## Appeal Decision

### Appeal Ref: APP/R5510/D/22/3298755

#### 14 Saxony Parade, Hayes, Middlesex UB3 2TQ

- The appeal is made under section 78 of the Town and Country Planning Act 1990 against a refusal to grant planning permission.
  - The appeal is made by Mrs S Shazada against the decision of the Council of the London Borough of Hillingdon.
  - The application Ref 75320/APP/2021/3522, dated 4 May 2021, was refused by notice dated 4 March 2022.
  - The development proposed is first floor rear extension.
-

EXISTING FIRST FLOOR PLAN.

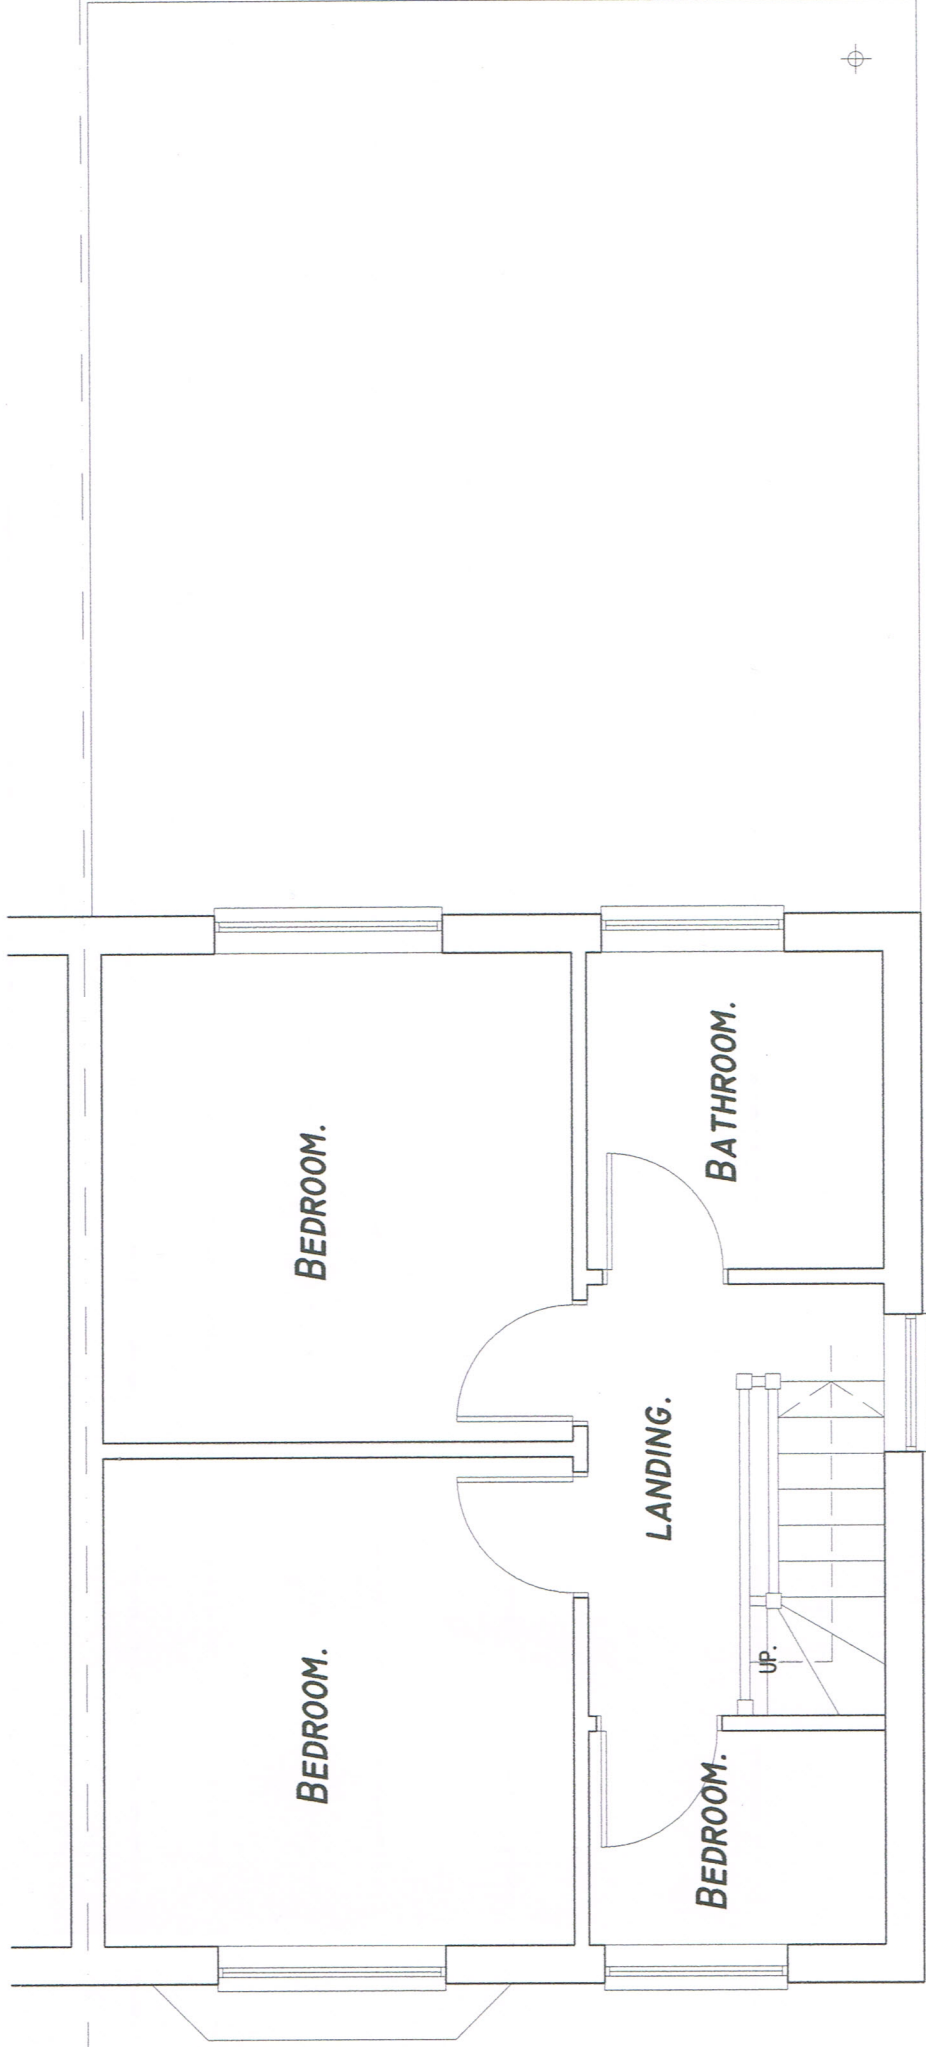
18. The existing floorplans submitted with this appeal show 4 existing bedrooms in the appeal property. The proposal would enlarge one of these and would not add more bedrooms. Therefore, while the existing amenity space provision may be below the required LPP2 standard, the proposal would not lead to an increase of habitable rooms or a need for additional amenity space.

Drawing: **PROPOSED ELEVATIONS.**

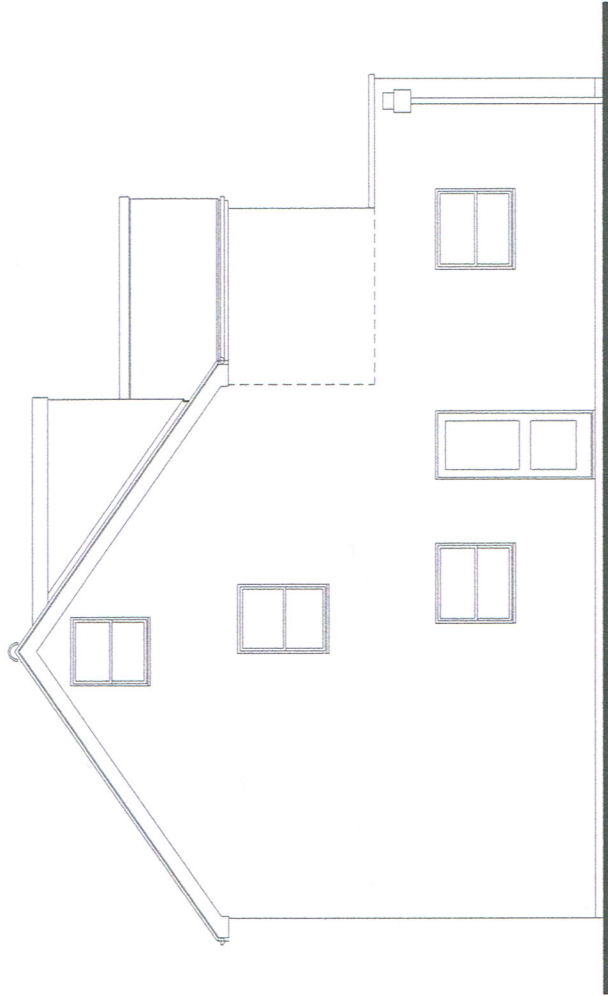
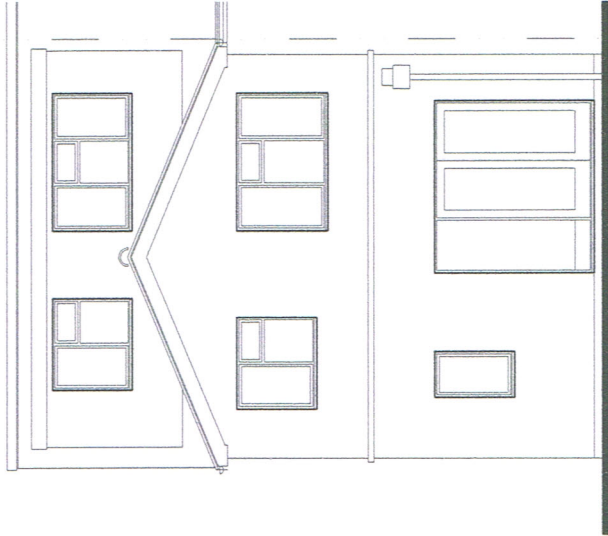
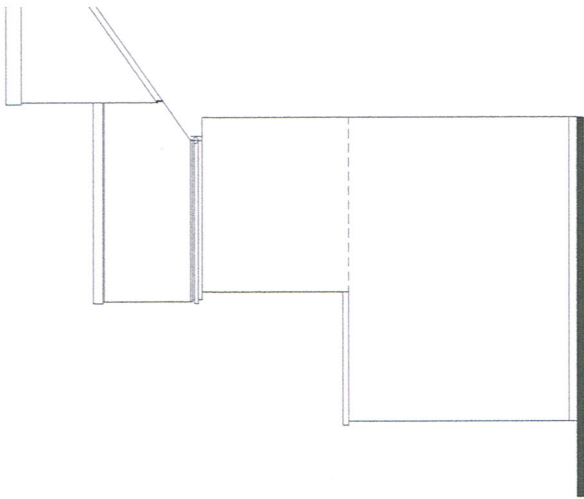
7. The property has already been substantially extended, but part of the rear elevation remains visible beside the existing first-floor extension. Although relatively modest in relation to the existing extensions, the appeal proposal would nonetheless add significant further bulk, mass, and scale to the existing rear extensions. It would fill the remaining space at first-floor level, completing a total reimagining of the rear elevation and significantly altering the existing dwelling. Cumulatively, the rear extensions would dominate the original dwelling and would not to be subordinate to it.

8. Furthermore, the proposal would create a wide, shallow roof over the combined first-floor extensions, relating poorly to the pitch of the main roof and creating a very awkward relationship with the rear dormer, to the detriment of the appearance of the dwelling. The existing first-floor extension also interrupts the dormer, but it is of far smaller scale than this proposal, and its design is therefore not as harmful as the appeal proposal.

PROPOSED FIRST FLOOR PLAN.

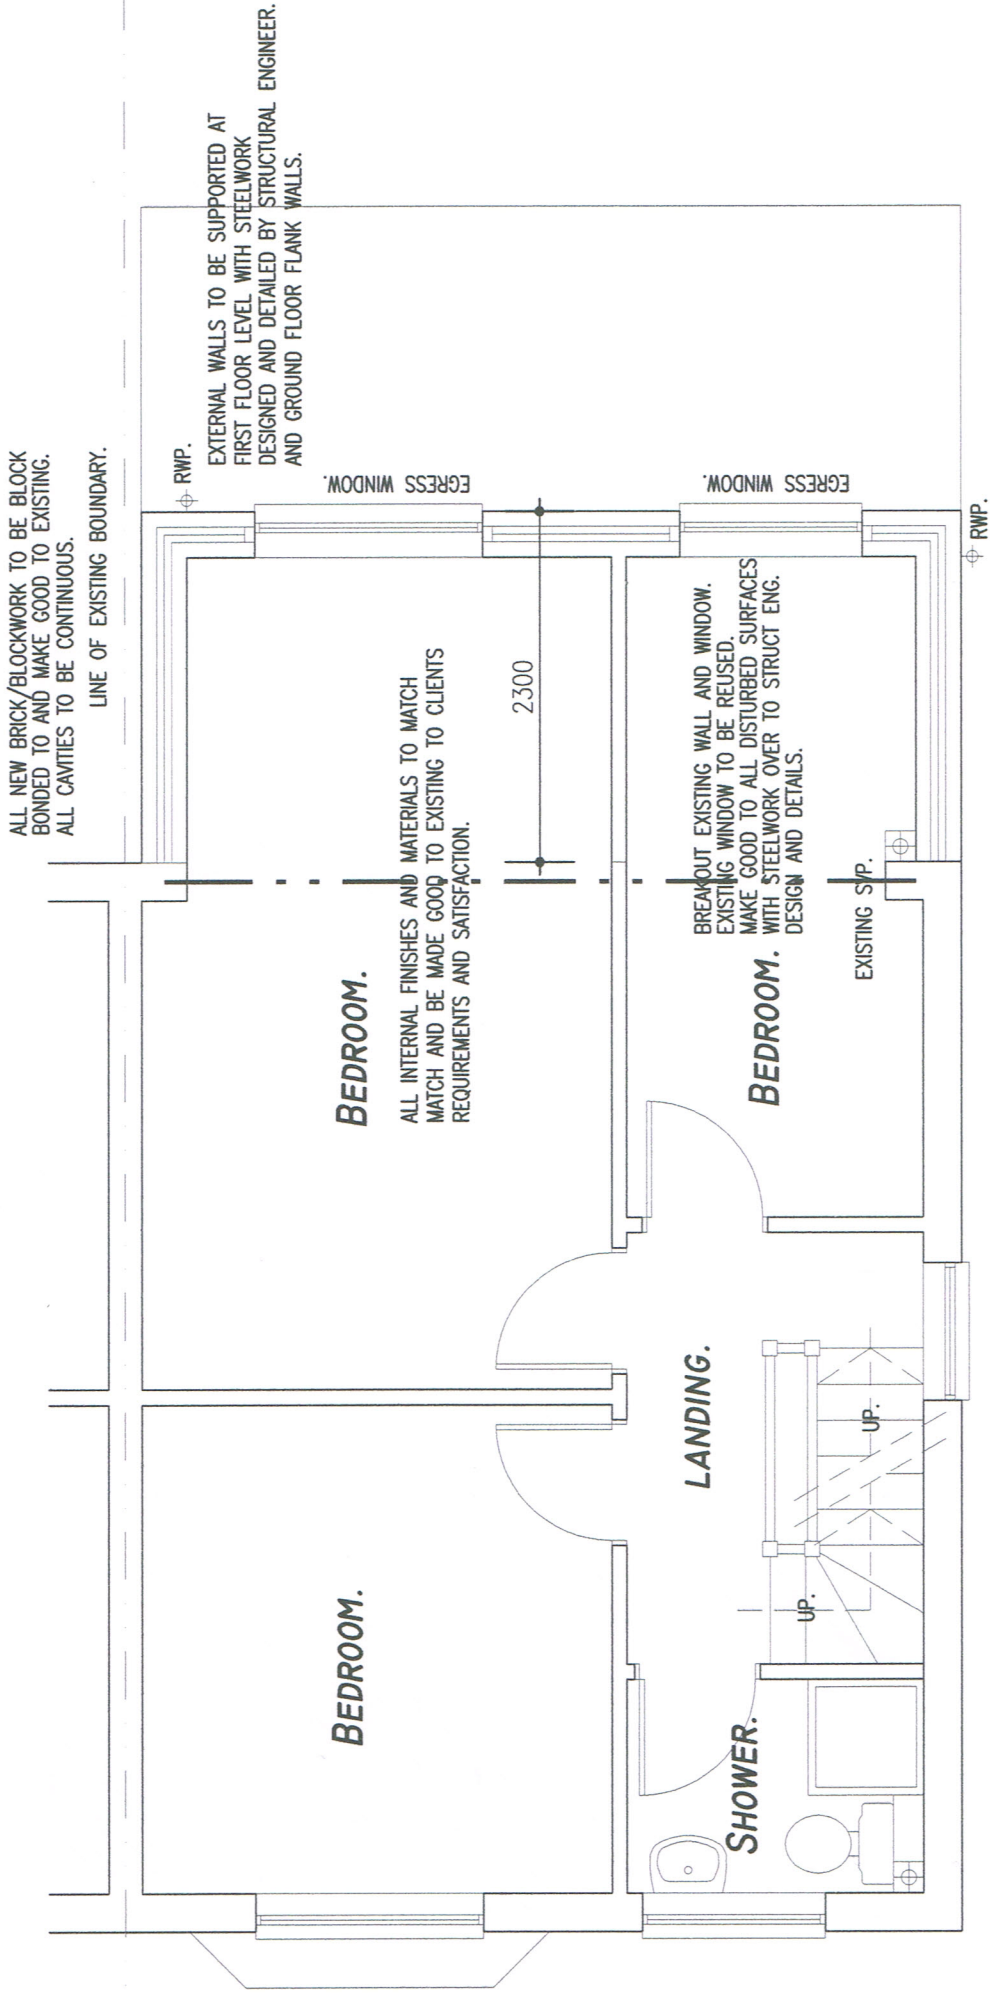
12. The existing first-floor extension is set well away from the boundary with No 16, which does not benefit from any rear extension. It therefore has a limited impact on light and outlook to that property.
13. The proposal would extend almost up to the boundary with No 16 and be 2300mm deep. It would therefore breach a 45-degree line of sight drawn from the centre of the nearest neighbouring first-floor window by some distance. The additional bulk, mass, and scale of the proposed extension would make it a dominant feature when seen from the first-floor window of No 16. It would also create a significant sense of enclosure from both the ground and first-floor

windows of that property. It would therefore result in a significant and unacceptably harmful loss of outlook from No 16.

14. The existing dwelling and No 12 already create some shading of No 16 in the afternoons. However, due to its proximity, height and orientation, I consider that the proposed extension would result in further shading of the nearest windows of that neighbouring property. While the additional shading would occur for a relatively short time, it would nevertheless adversely impact on the light reaching the adjacent property, further harming the occupiers' living conditions.
